# CITY OF ALBUQUERQUE

Re: **Dutch Bros. Coffee NM0203**  
**220 98th Street NW**  
**Traffic Circulation Layout**  
Architect's Stamp date 11/30/2022 (K09D048B)

Based upon the information provided in your resubmittal received 12-2-2022, the above referenced plan cannot be approved for Building Permit until the following comments are addressed:

Job Number  
**22187**  
Sheet  
**C2.0**  
2019 DB  
Franchising USA, LLC

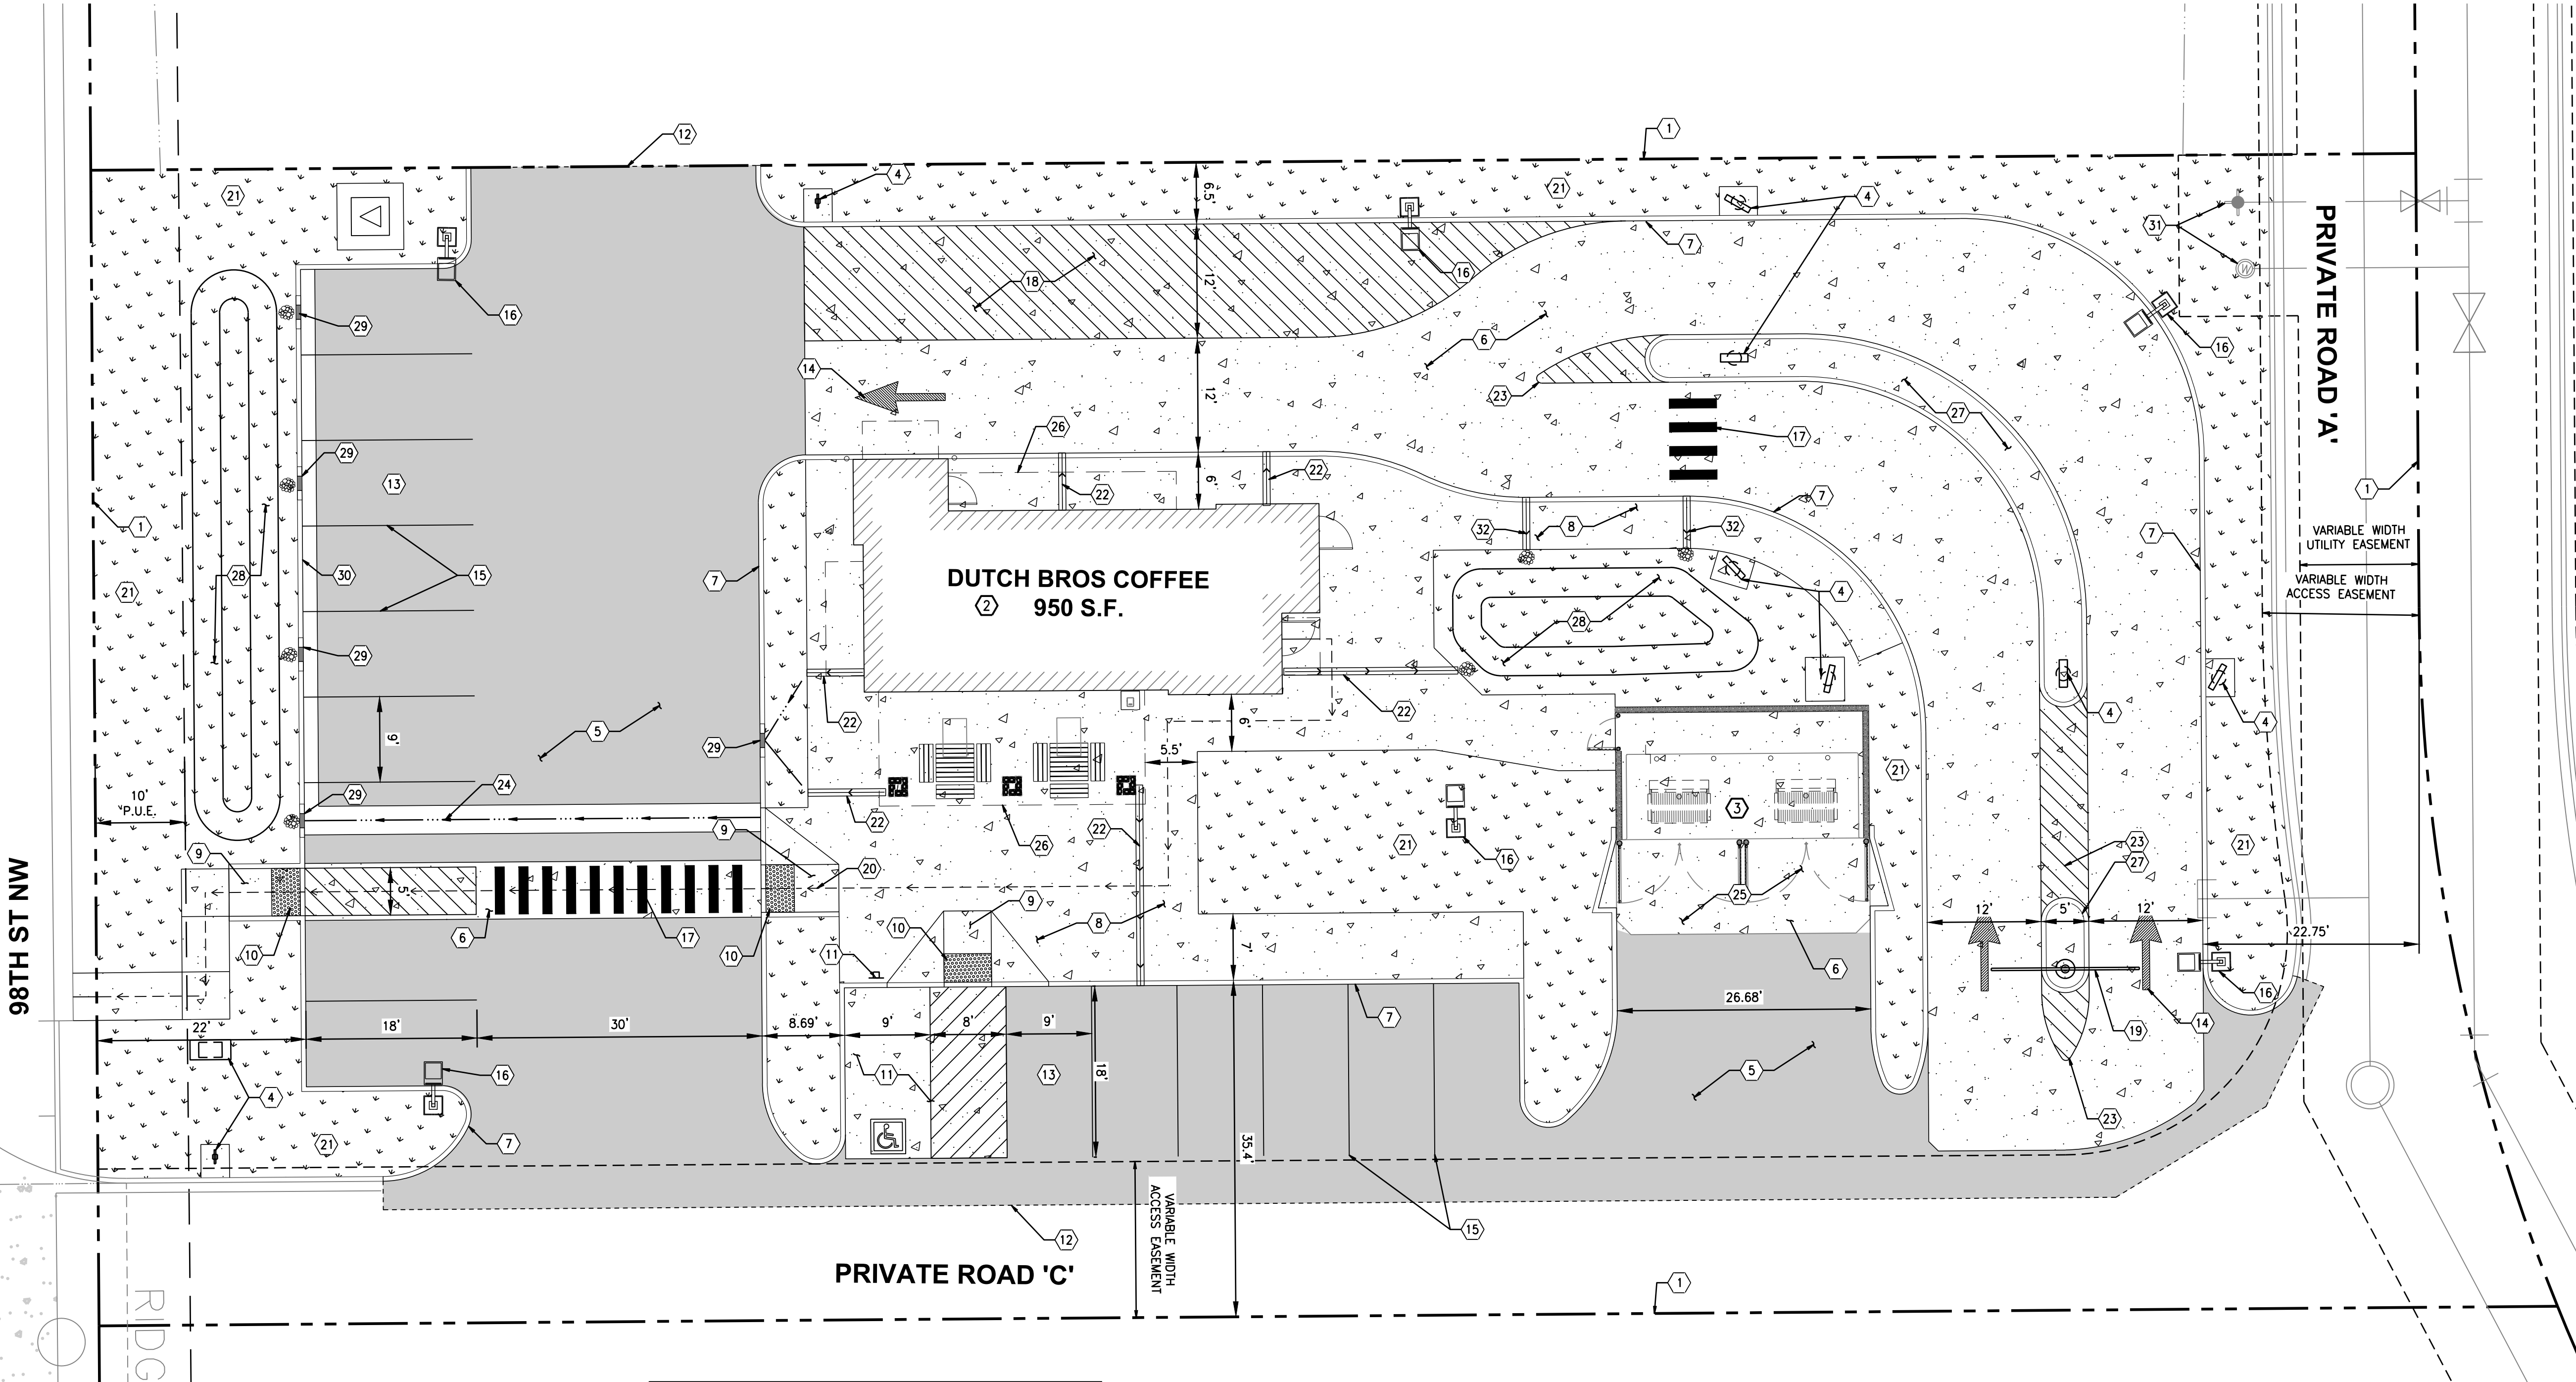
The submitted TCL is not complied as they should be. The TCL submittal should only address and present information related to the TCL. The TCL drawing package is used by our inspectors when doing the certification of occupancy. I sent a set of selected drawing from your construction plan set that closely represents a TCL submittal. Please recompile your submittal presenting information that relates to the TCL only. You can refer to the check list that were previously provided. This submittal is being rejected due to being incomplete and not what the City expects for a TCL.

1. Include bicycle and motorcycle parking in the parking calculation, **Not done**
2. Reference all COA Standard Drawing numbers for improvements in the City ROW. **Not done**

3. Add a general note requiring City of Albuquerque Work Order plans for work within the City's ROW. **Not done.**
4. Identify street right-of-way widths and pavement widths and medians for adjacent streets. **Not done**

5. Developer must provide sidewalk according to the COA DMP requirements along 98th St. **Not done**
6. Signs. Provide sign face detail drawings for all proposed traffic signs. One-way, Do Not Enter, Motorcycle Parking, Handicapped parking with fine. **One-way and motorcycle signs missing**

7. Place the one-way and do not enter signs with appropriate pavement markings in the site plan. **Not done**
8. Add one Motorcycle Parking space with sign **Not done**

9. Add three bicycle parking spaces. Provide bicycle rack details. **Not done**
10. Build the 2 lane driveway at 98<sup>th</sup> with curb returns and valley gutter. **Not done**

11. Show the delivery truck path and assure that there is sufficient clearance. **Not done**
12. Provide Fire Marshall and Solid Waste approvals. **Not in plans**

13. Increase the pedestrian sidewalk/pathway from the public sidewalk to the main entrance to 6 feet. Plans have a 5-foot wide path. **Dimension missing, not clear where the sidewalk is.**
14. Show the sight triangles for the driveway on 98<sup>th</sup> and the driveway into the site. **Not done**
